CITY OF ALBUQUERQUE

**RE: Patz Warehouse
Grading and Drainage Plan
Engineer's Stamp Date 11-1-2016 (File: G14D088)**

**Re: Patz – Warehouse/Apartment
406 Veranda NW
Traffic Circulation Layout
Architect's Stamp dated 09-14-16 (G14D088)**

Re: Patz – Warehouse/Apartment
406 Veranda NW
Traffic Circulation Layout
Architect's Stamp 09-14-16 (G14D088)

PATZ - WHAREHOUSE/APPARTMENT
406 VERANDA RD N.W.
DATE: 08-08-2016
PROJECT #:

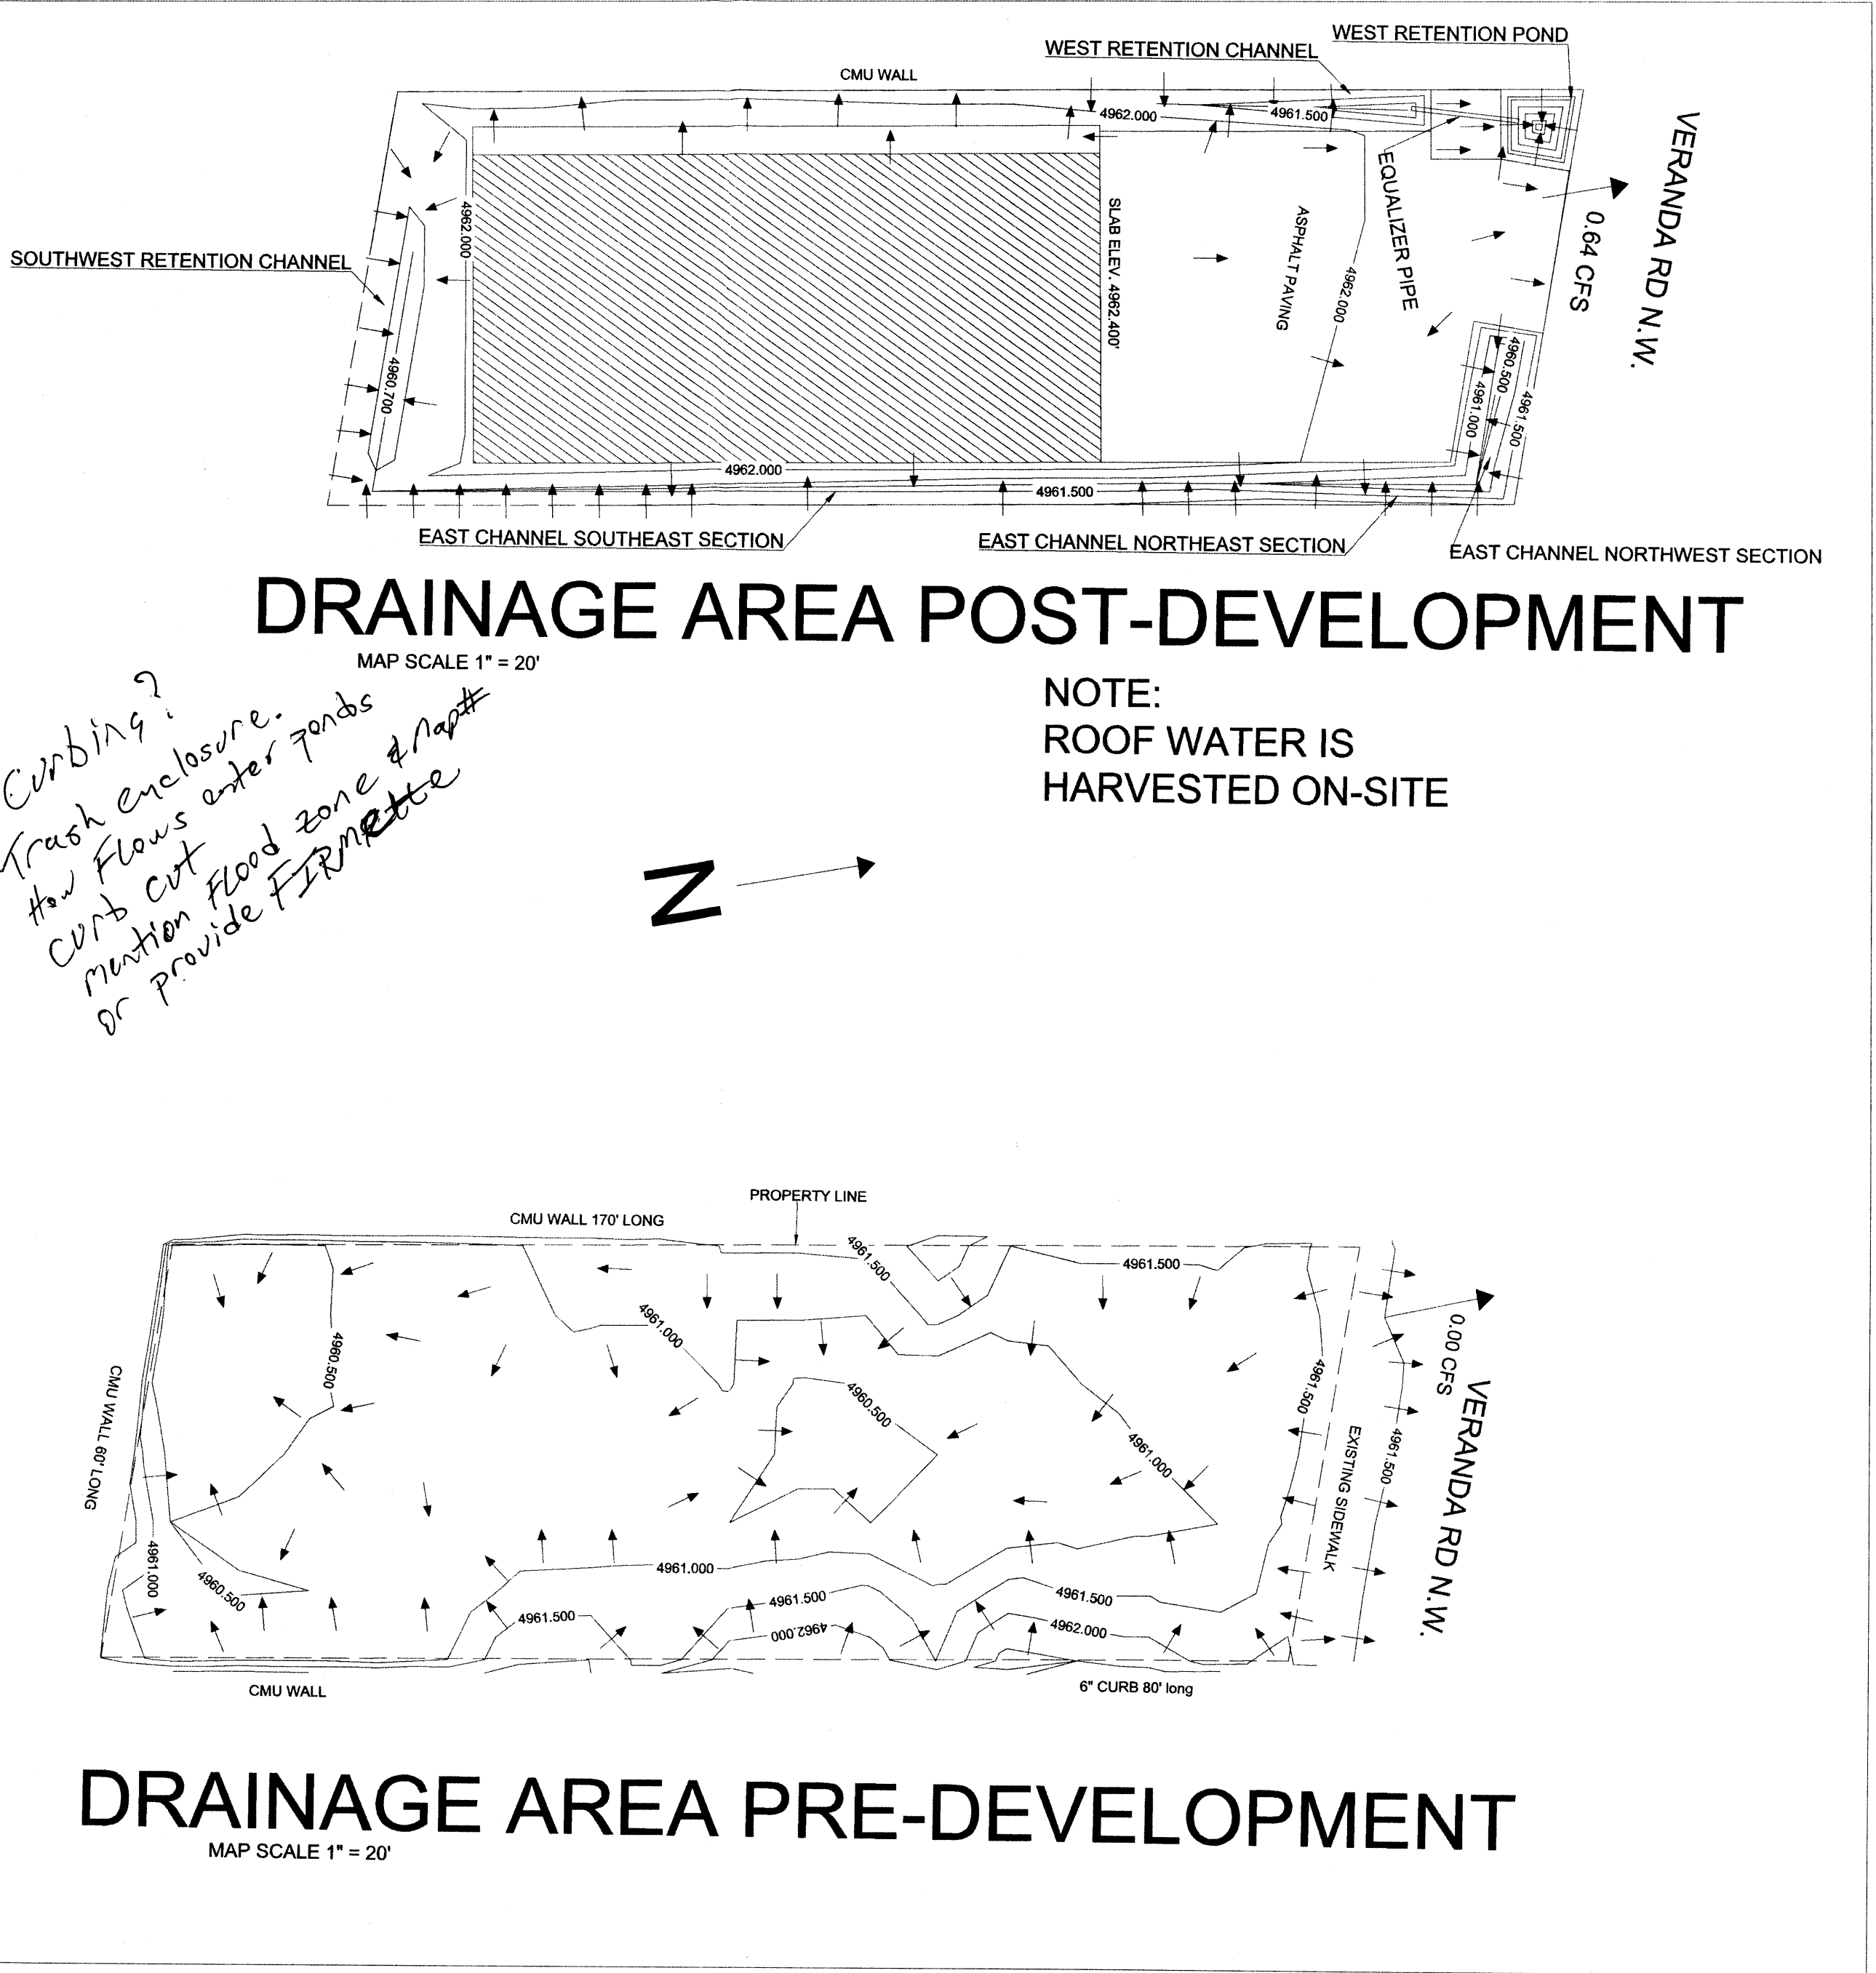
- Provide build notes on the G&D plan.
- Label the trash enclosure.
- Provide the distance's from the building to property line.
- Is curbing provided at the edge of all pavement? If so, how will flows enter the ponds or swales?
- How is roof water being harvested?
- Provide roof flows.
- Provide a FIRMette from the FEMA web site or mention the map page and what flood zone the property is located.
- Is the $\frac{3}{4}$ " rod a monument or a survey stake?

SITE PLAN
1" = 20'-0"

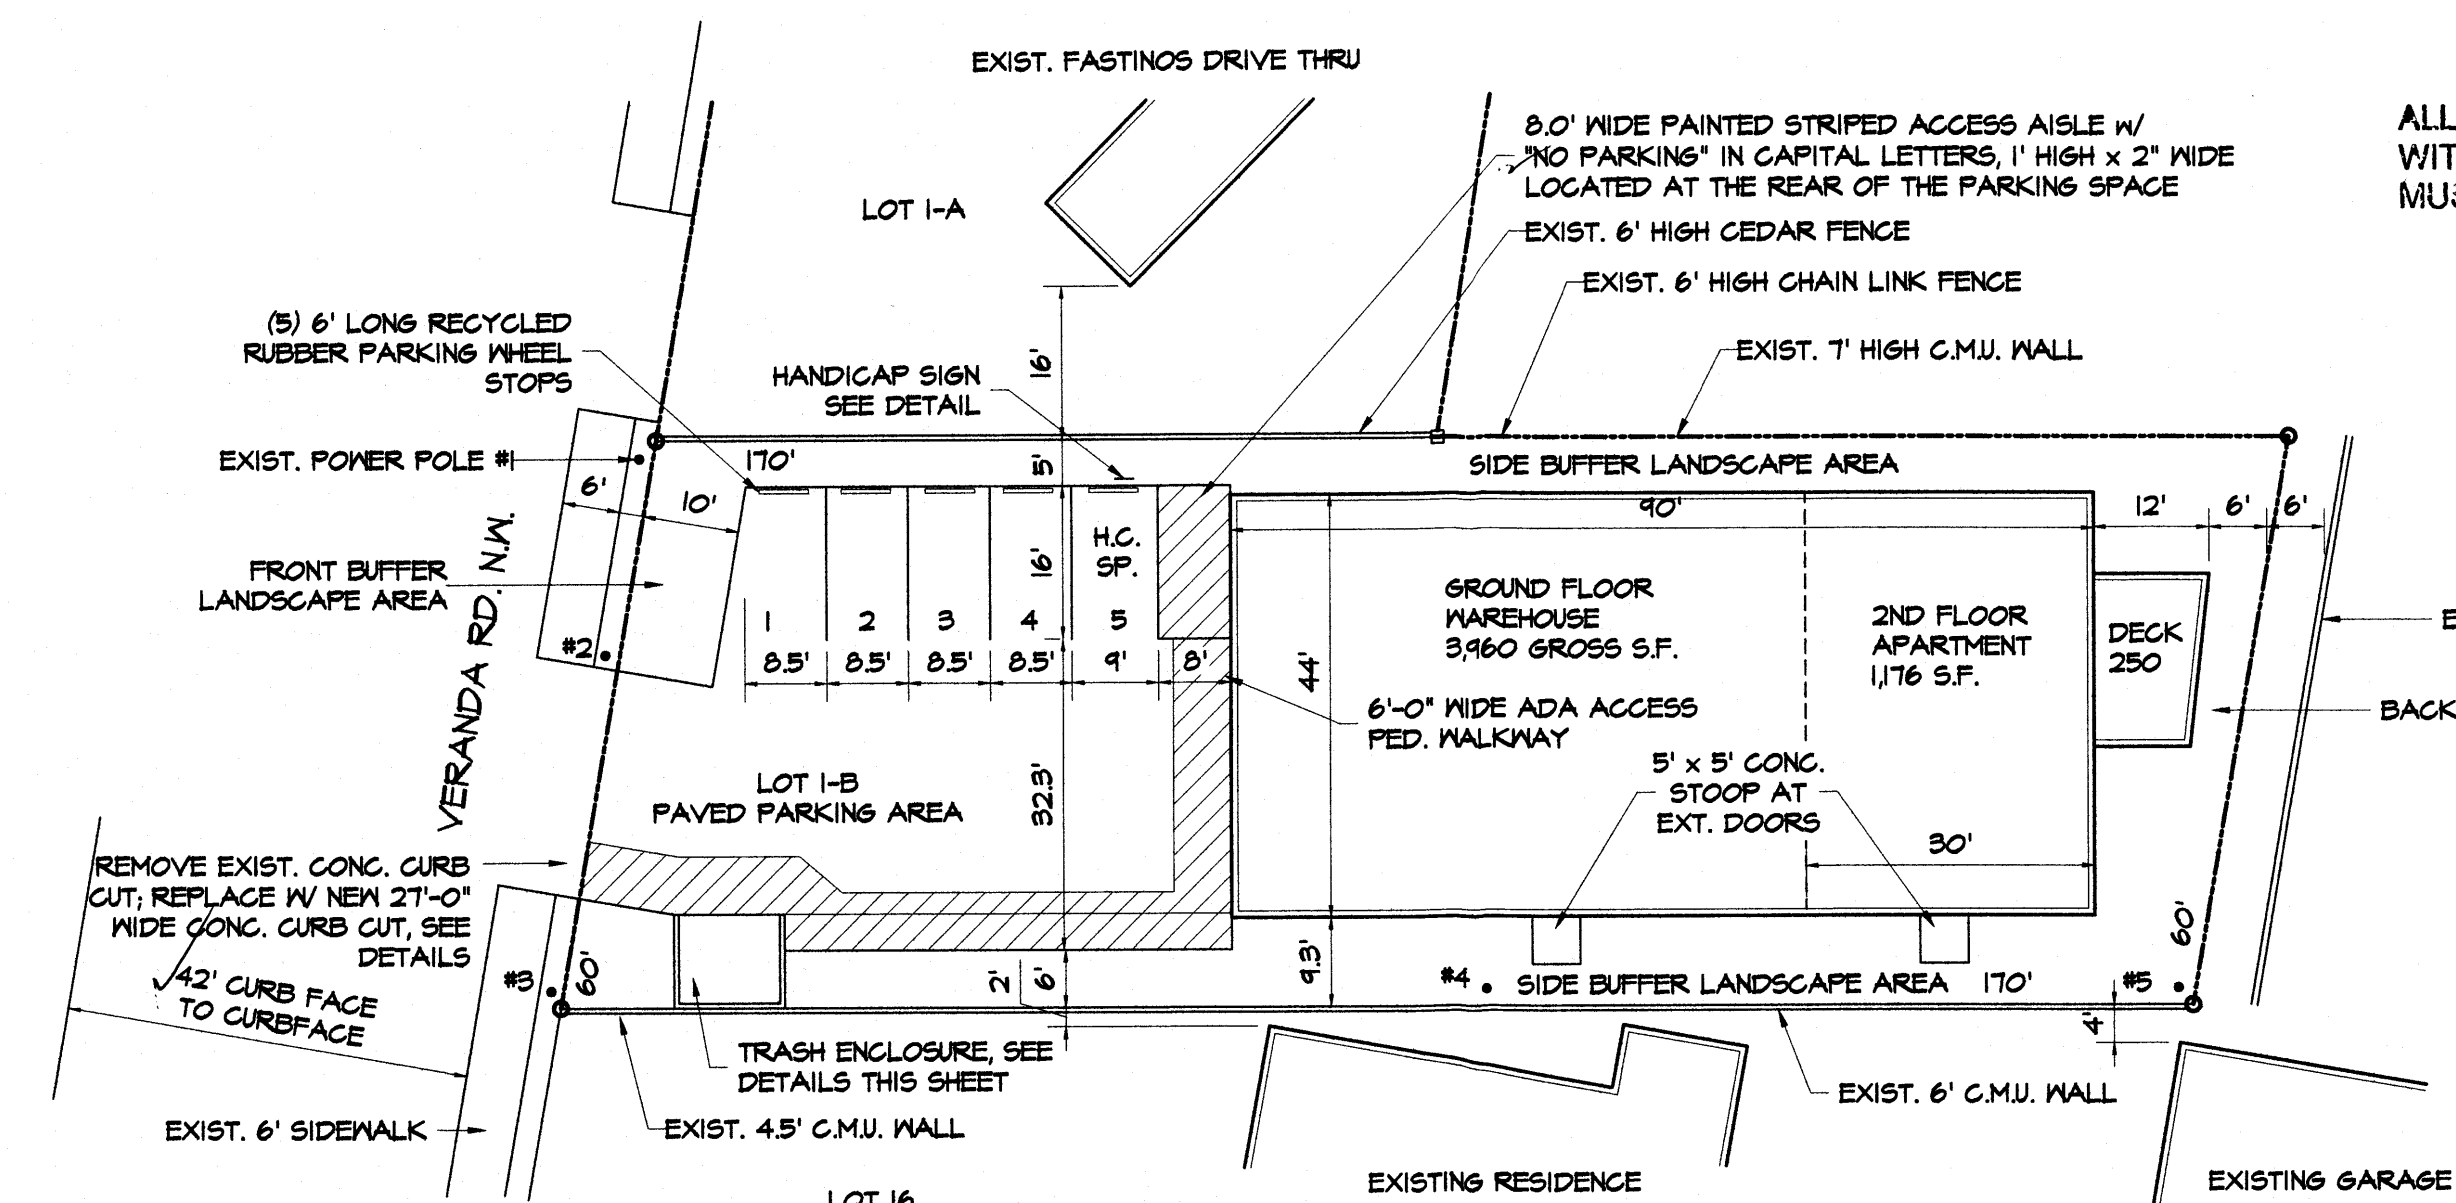
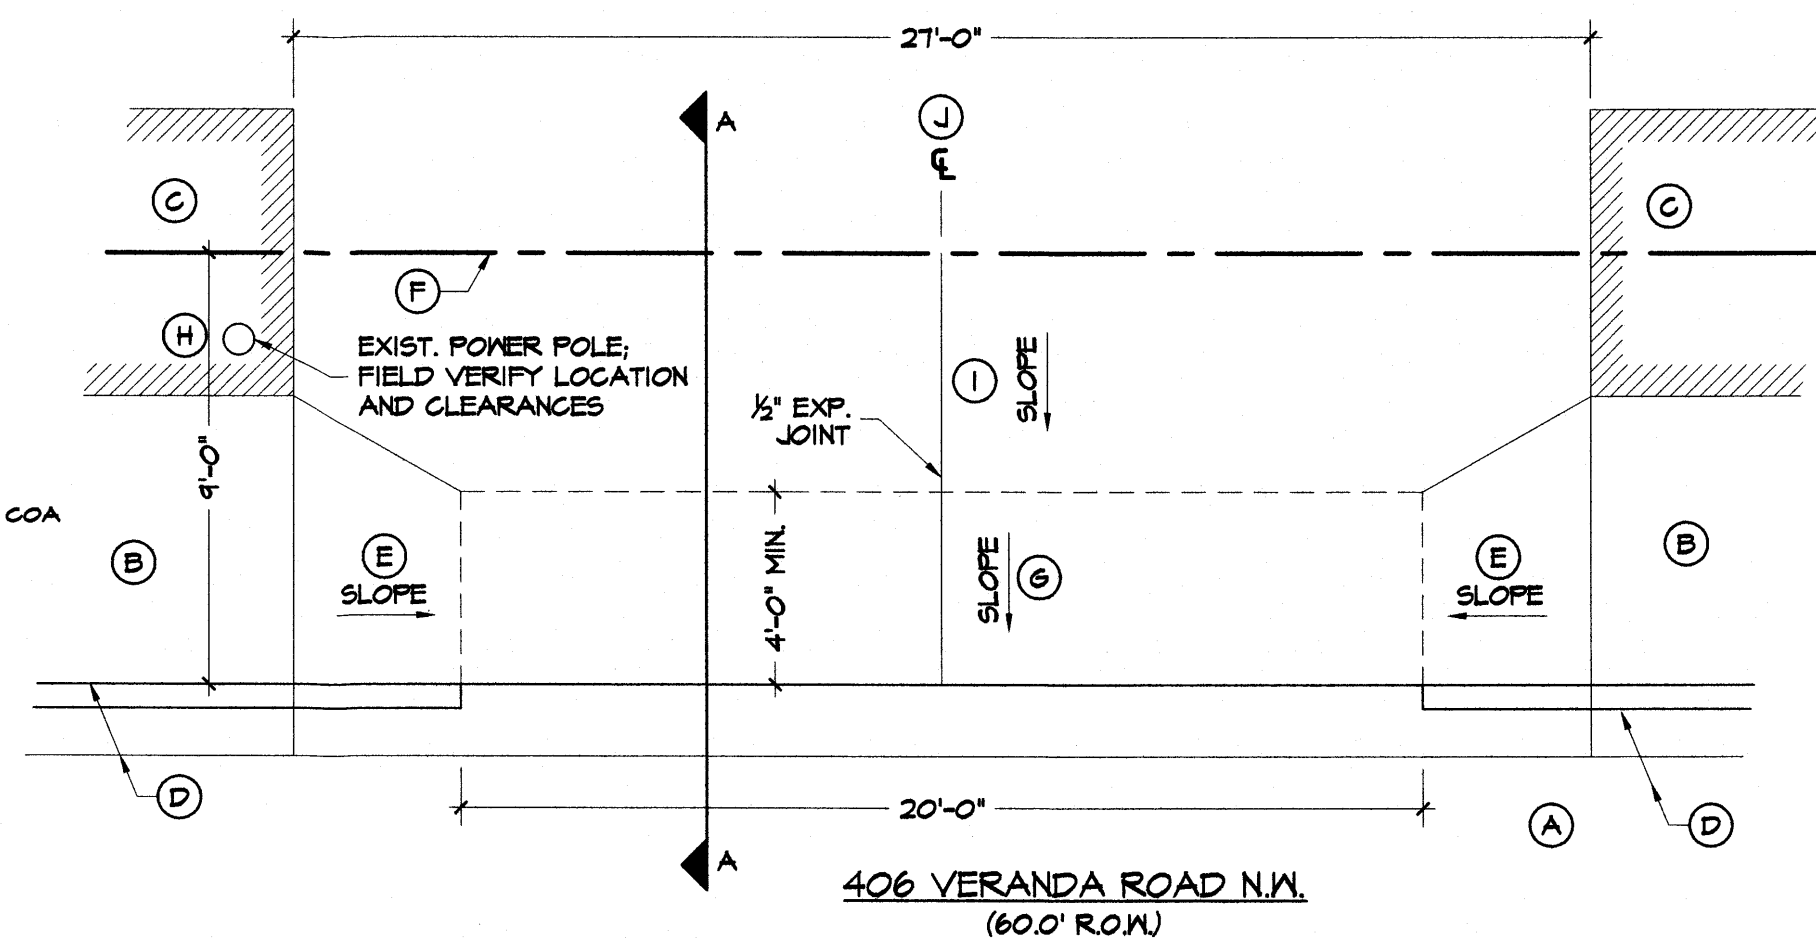
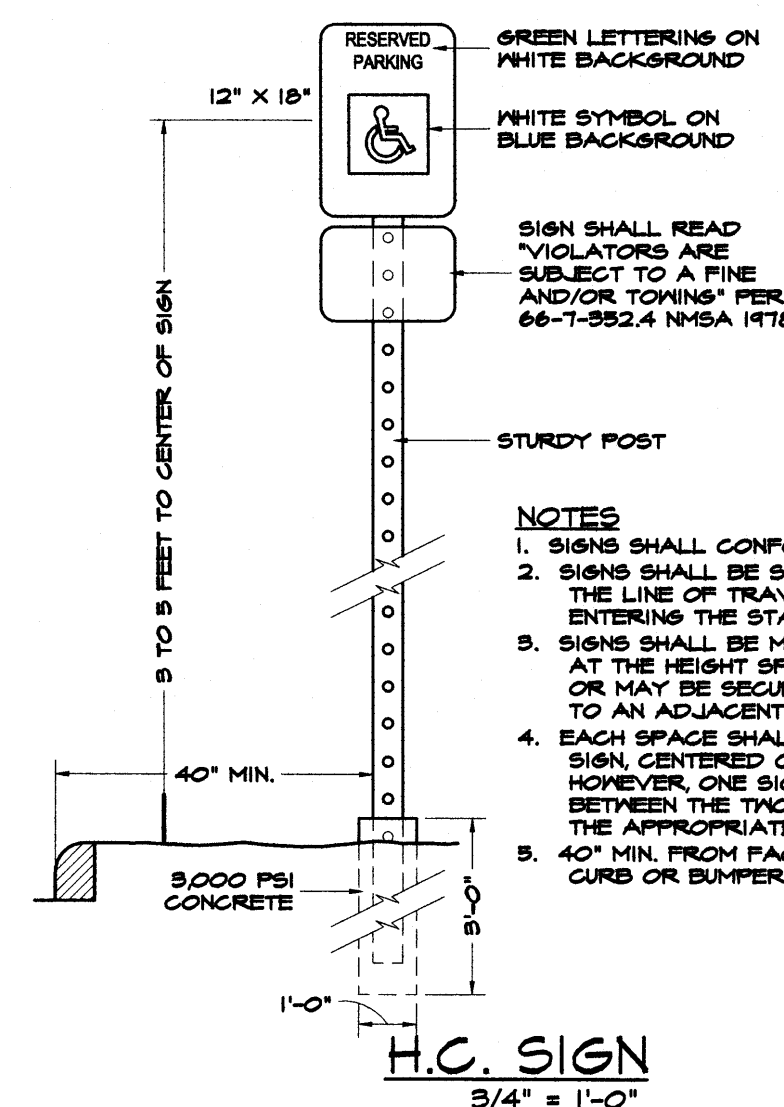
1. Please show a vicinity map showing the location of the development in relation to streets and well known landmarks.
2. Identify the right of way width, medians, curb cuts, and street widths on Veranda NW.

3. The handicap accessible spaces must include an access aisle. Van accessible aisles should be 8ft wide.
4. The ADA accessible parking sign must have the required language per 66-7-352.4C NMSA 1978 **"Violators Are Subject to a Fine and/or Towing."** Please call out detail and location of HC signs.

5. The ADA access aisles shall have the words **"NO PARKING"** in capital letters, each of which shall be at least one foot high and at least two inches wide, placed at the rear of the parking space so as to be close to where an adjacent vehicle's rear tire would be placed. (66-1-4.1.B NMSA 1978)

6. Please dimension the 6 ft. wide ADA accessible pedestrian pathway required from the public sidewalk to the building entrances. Please locate pedestrian path to abut next to the west end side buffer landscape area.
